From: Laura Gibbons [REDACTED]
Sent: 15 September 2020 12:14
To: Planning.Responses [REDACTED]
Cc: Raymond Cole [REDACTED]
Subject: BE/91/20/DOC- Land West of New Barn Lane

Engineers Comments Regarding Condition 5- Surface Water Drainage

TITLE: ON-PLOT PROPOSED DRAINAGE LAYOUT

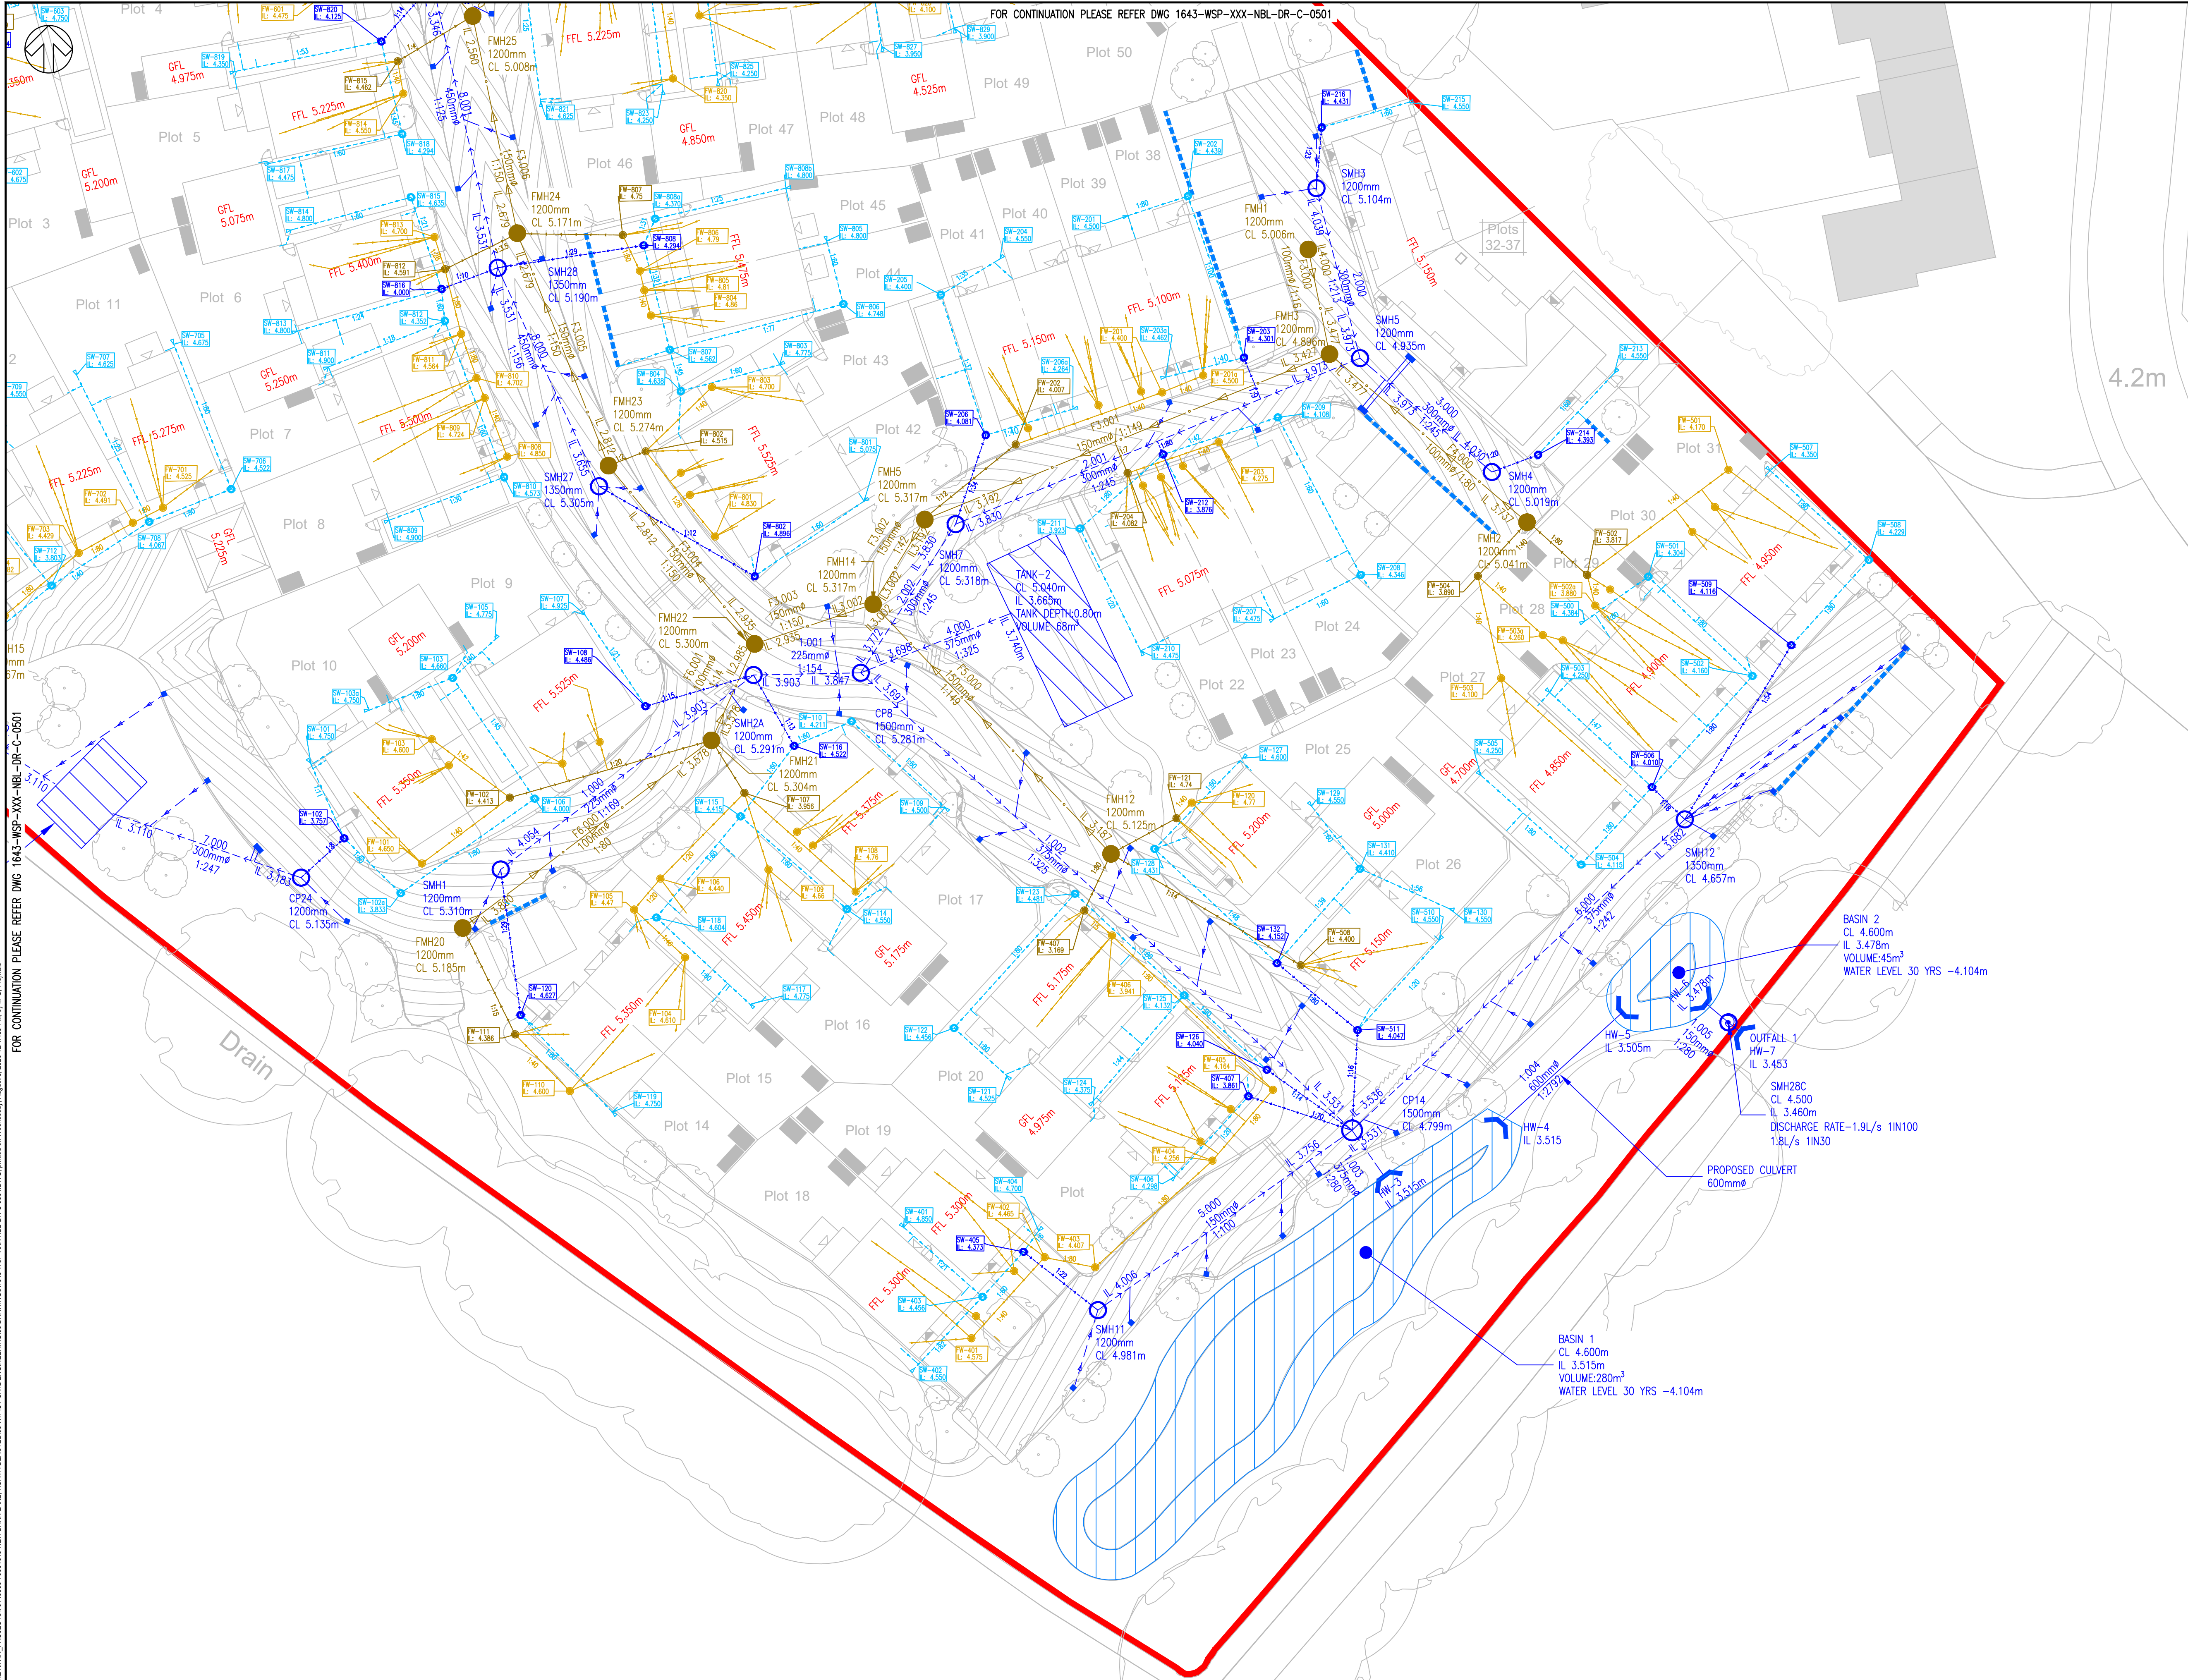
4. Impermeable areas plan. Preferably in dwg format to facilitate paperless review.
5. The proposed discharge rates are very low in some locations. A minimum permissible discharge rate of 2l/s is usually applied across the district because of the increased risk of blockage at lower flows. Please detail proposed aperture sizes so that this can be further reviewed.

13. Details of bed levels of ditches, including invert levels of pipes.

TITLE: ON PLOT HEADWALL STANDARD DETAILS

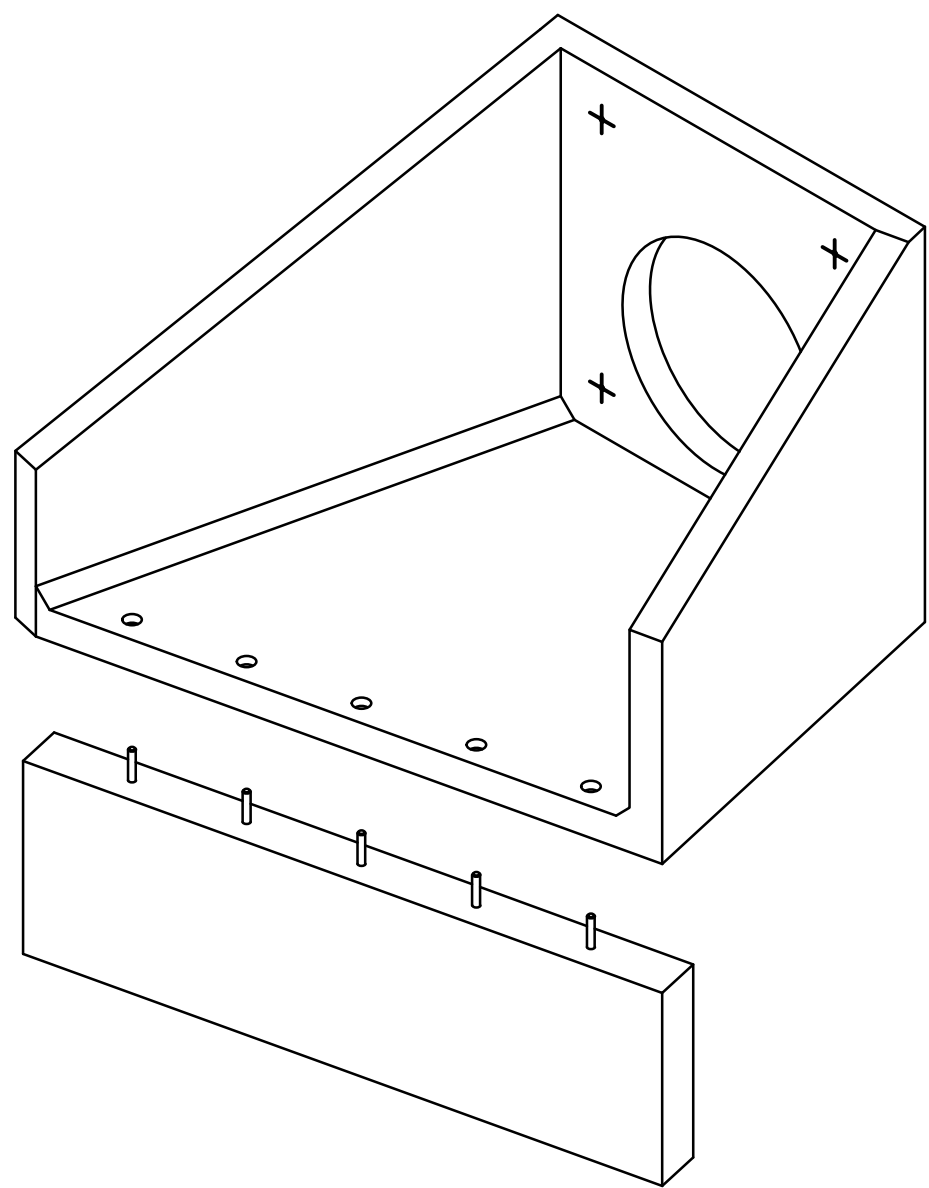
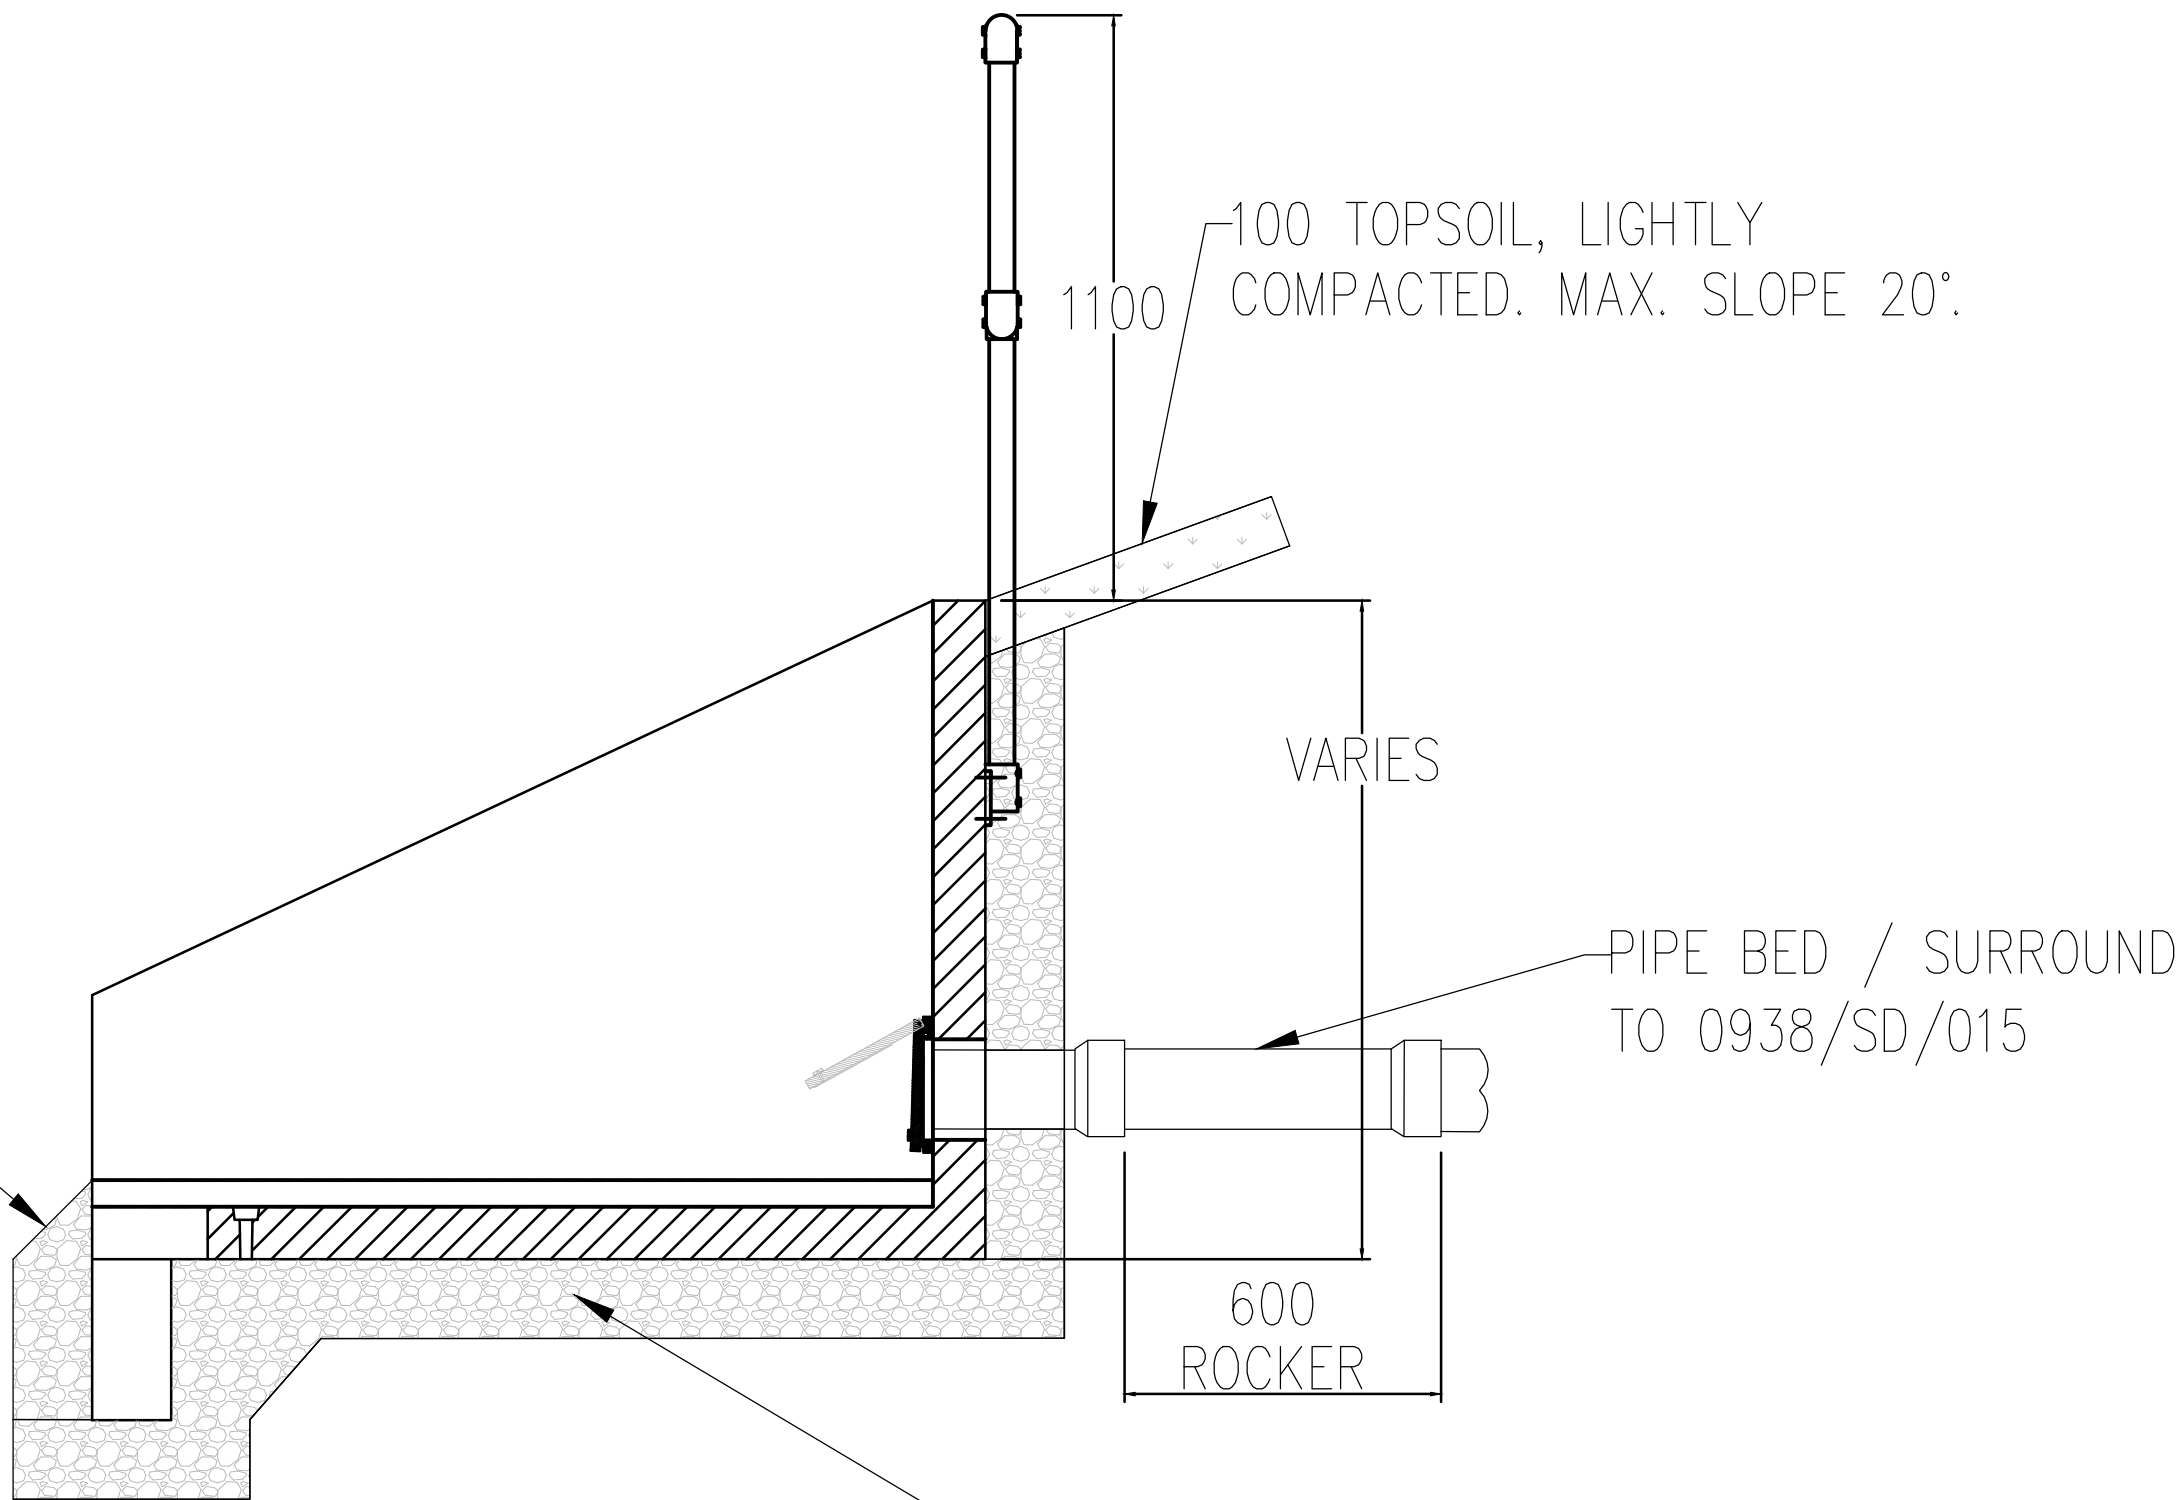
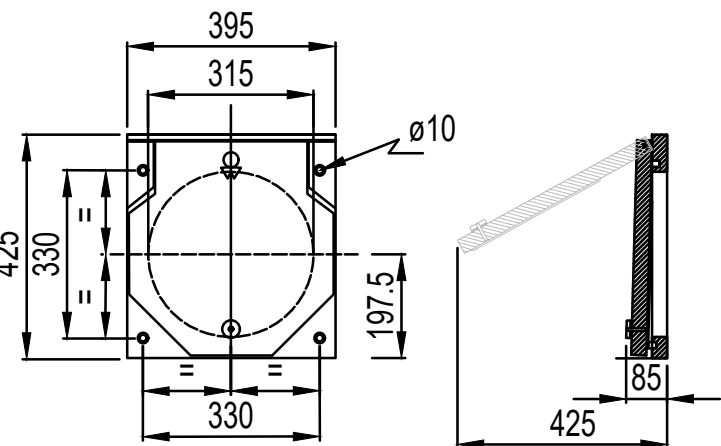
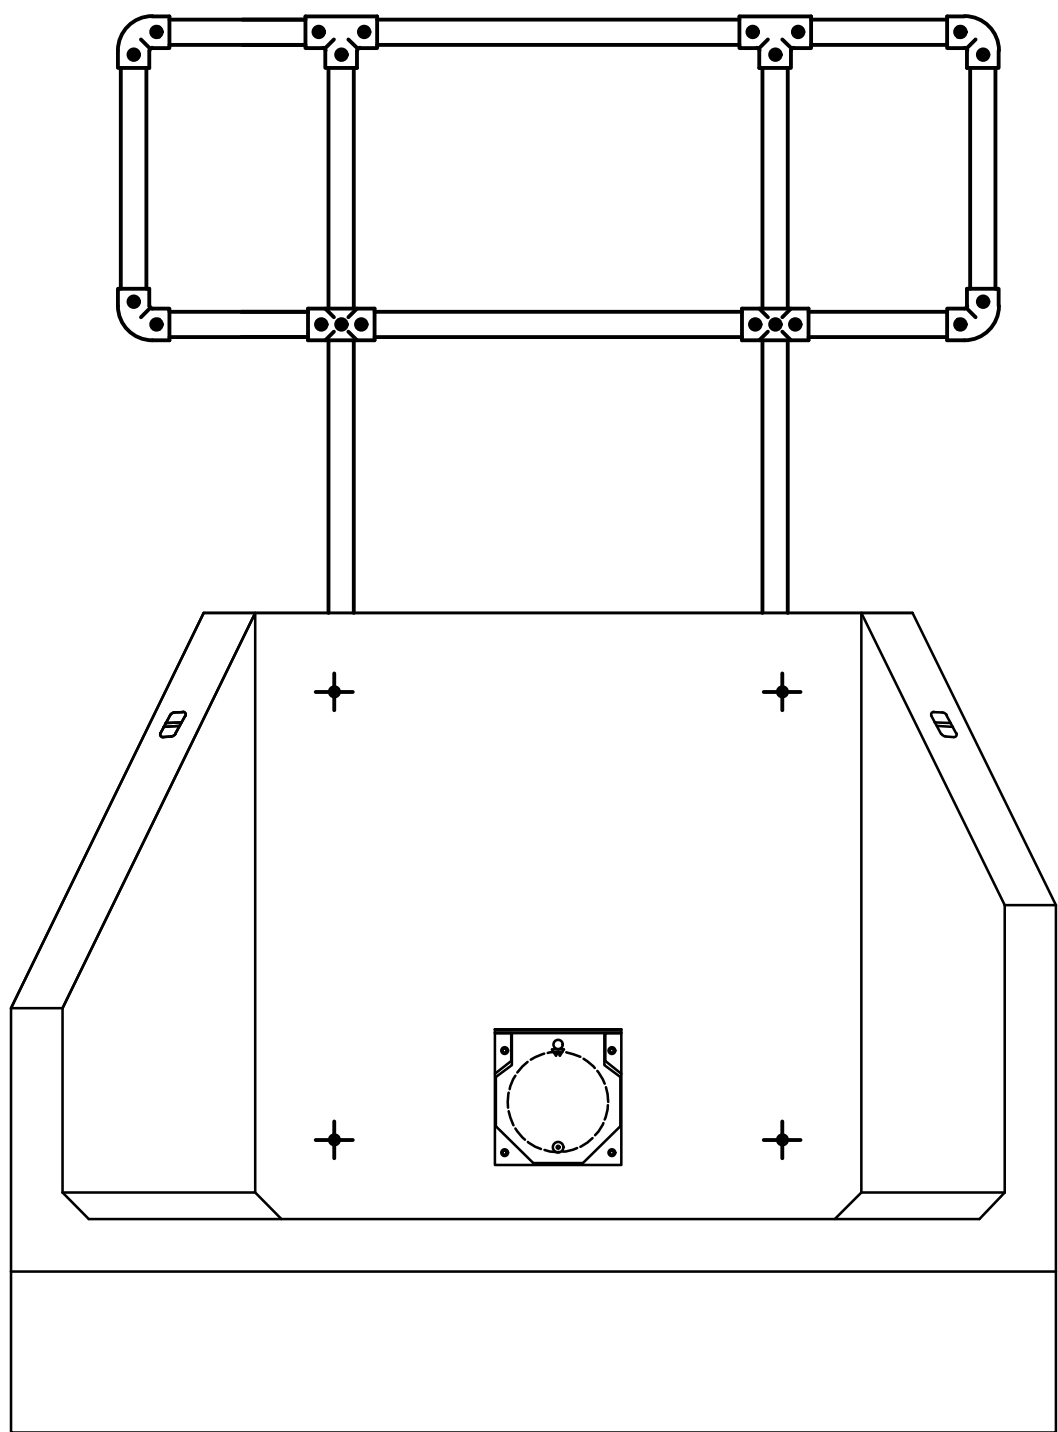
7. Site specific construction detail drawings of attenuation tanks.
8. Site specific construction details of all flow control devices and headwalls.
9. Flotation calculations supporting the design.
